**Application no: 22/02692/DISC**

**Location: Heyford Park, Camp Road, Upper Heyford, Bicester, OX25 5HD**

## **Transport Development Control**

**Condition 22: Objection**

PROJECT NO: 001 DRAWING NO: PH10_TM001 REVISION: A

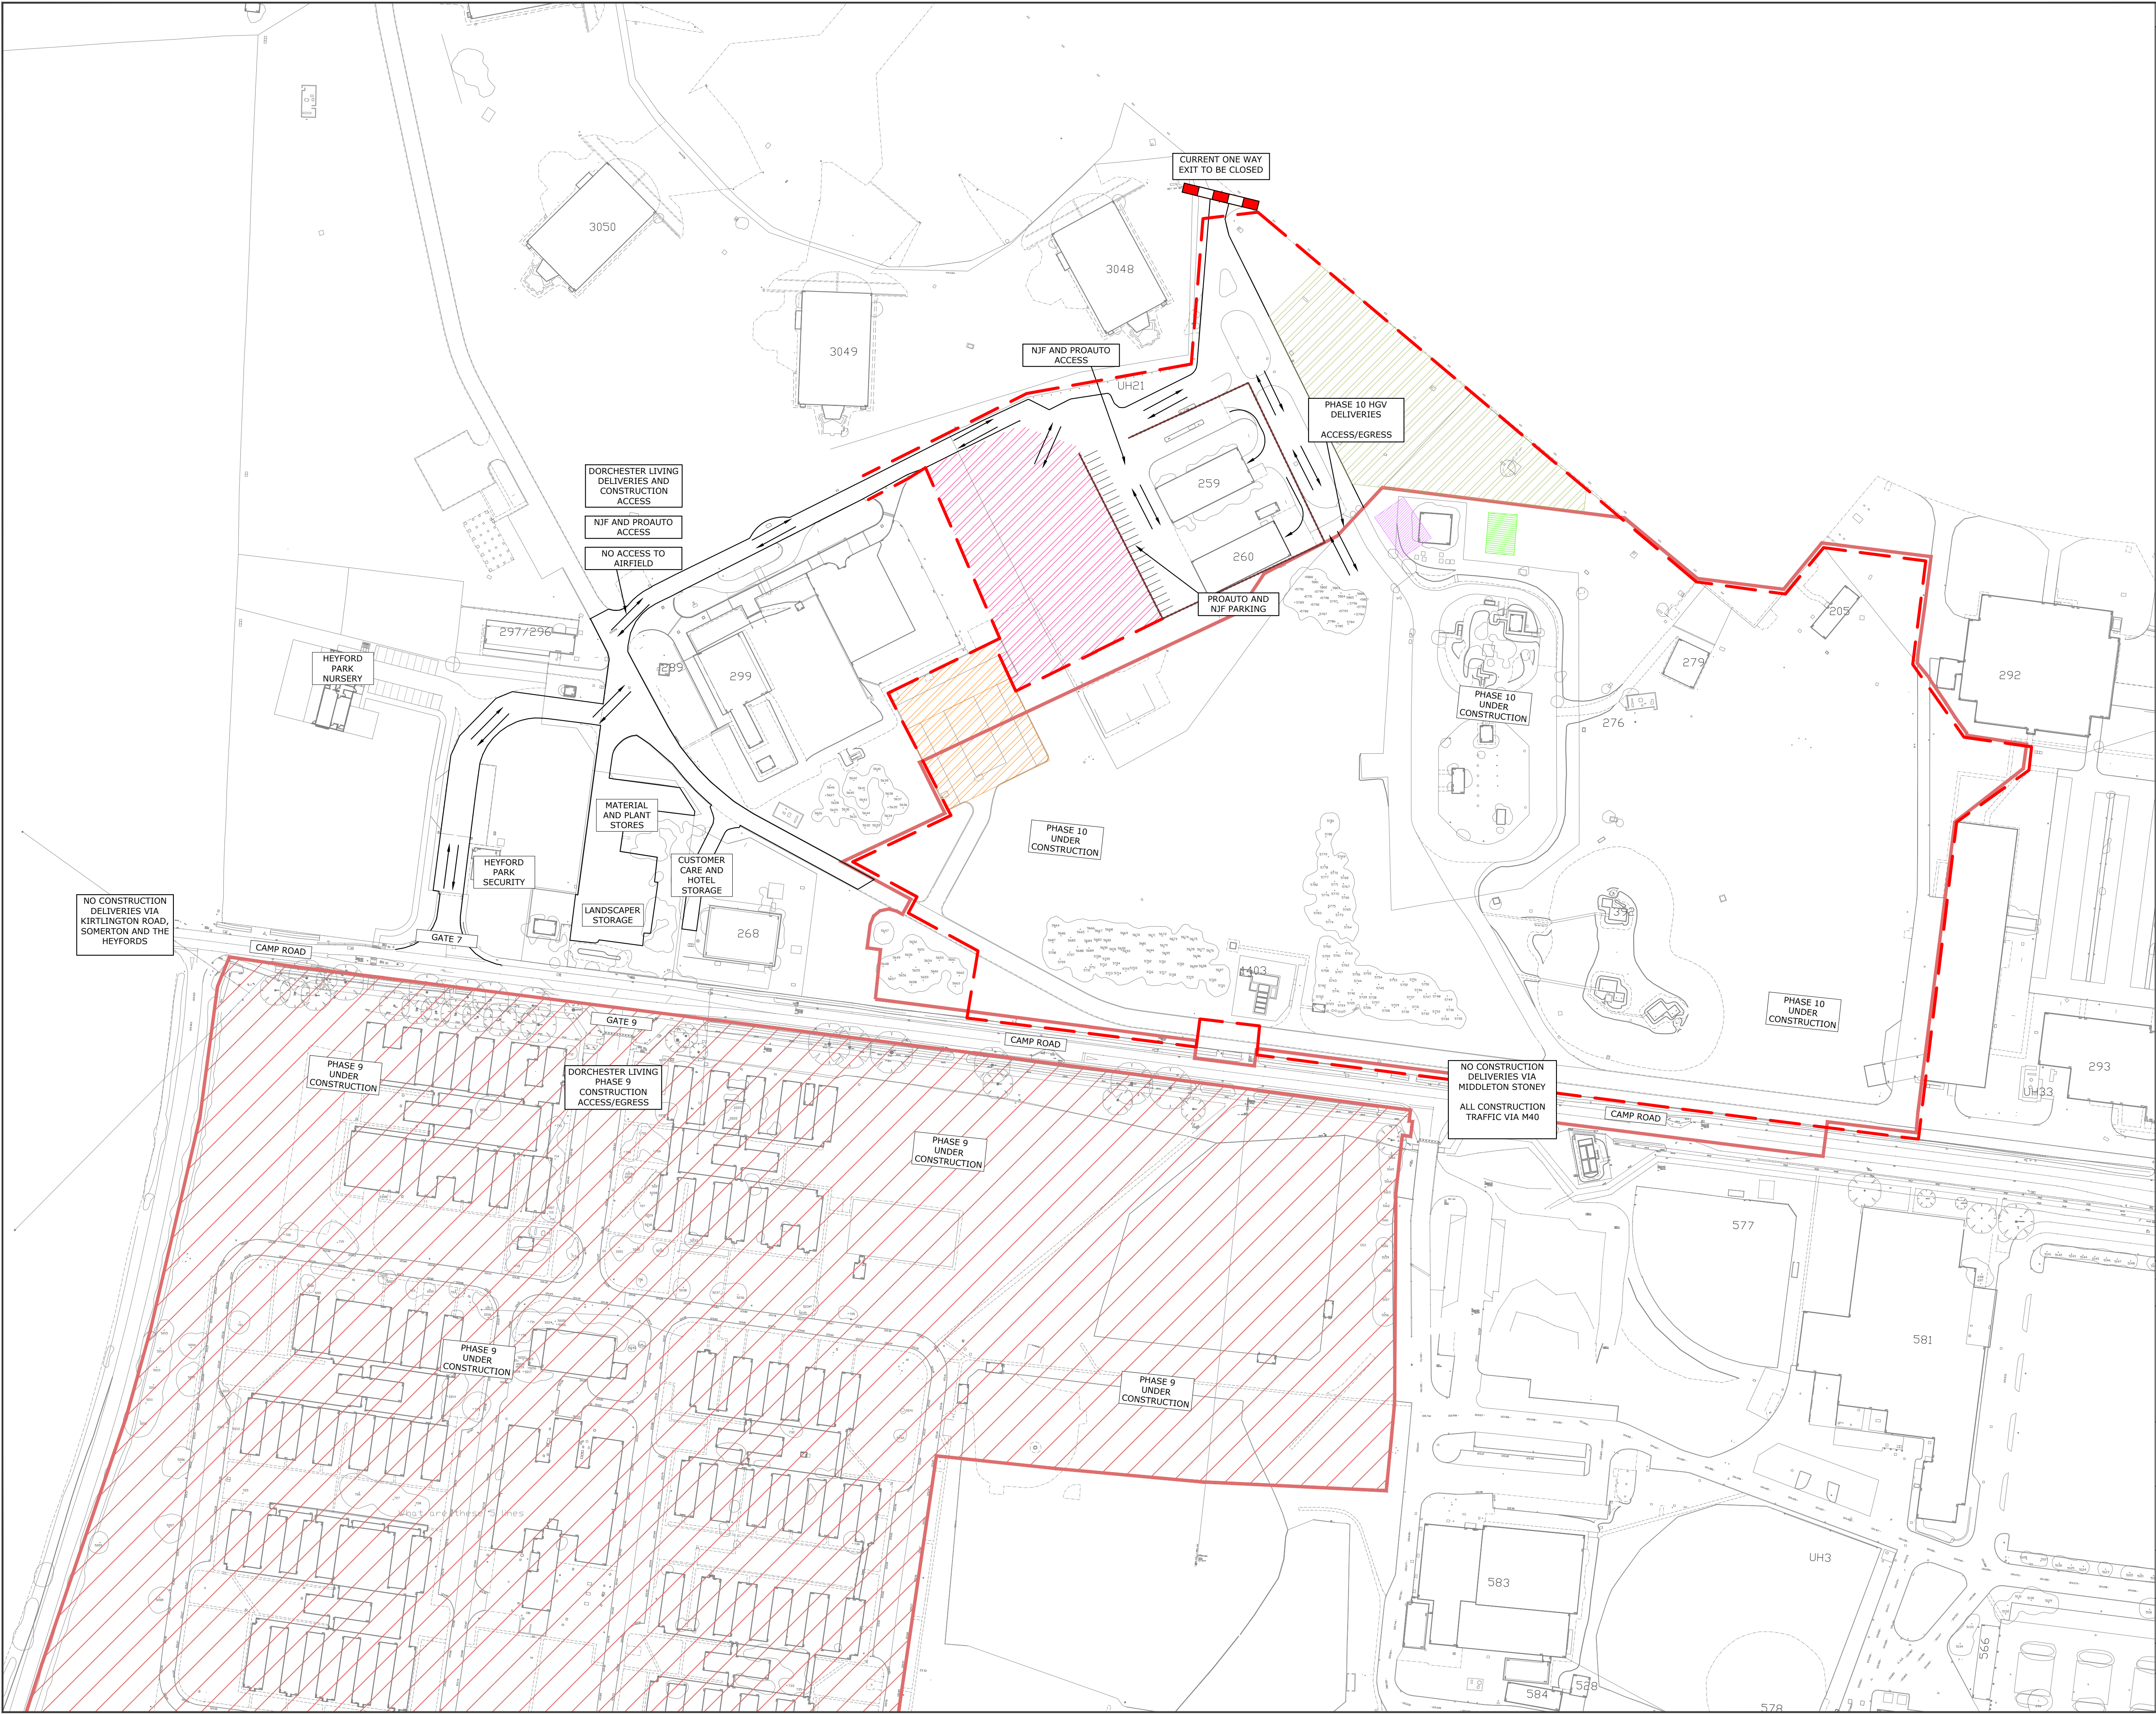
In order for Condition 22 to be discharged, the Construction Method Statement should be updated to show the following:

- Deliveries or movement of heavy construction vehicles should not occur between the hours of 07:30-09:30, 15:00-16:00 and 16:00-18:00. This is to avoid network peak hours and school pick up / drop off.
- Contact details of the Project Manager and Site Supervisor responsible for on-site works to be provided.
- A before-work commencement highway condition survey and agreement with a representative of the Highways Depot – contact 0845 310 1111. Final correspondence is required to be submitted.
- Local residents to be kept informed of significant deliveries and liaised with through the project. Contact details for person to whom issues should be raised with in first instance to be provided and a record kept of these and subsequent resolution
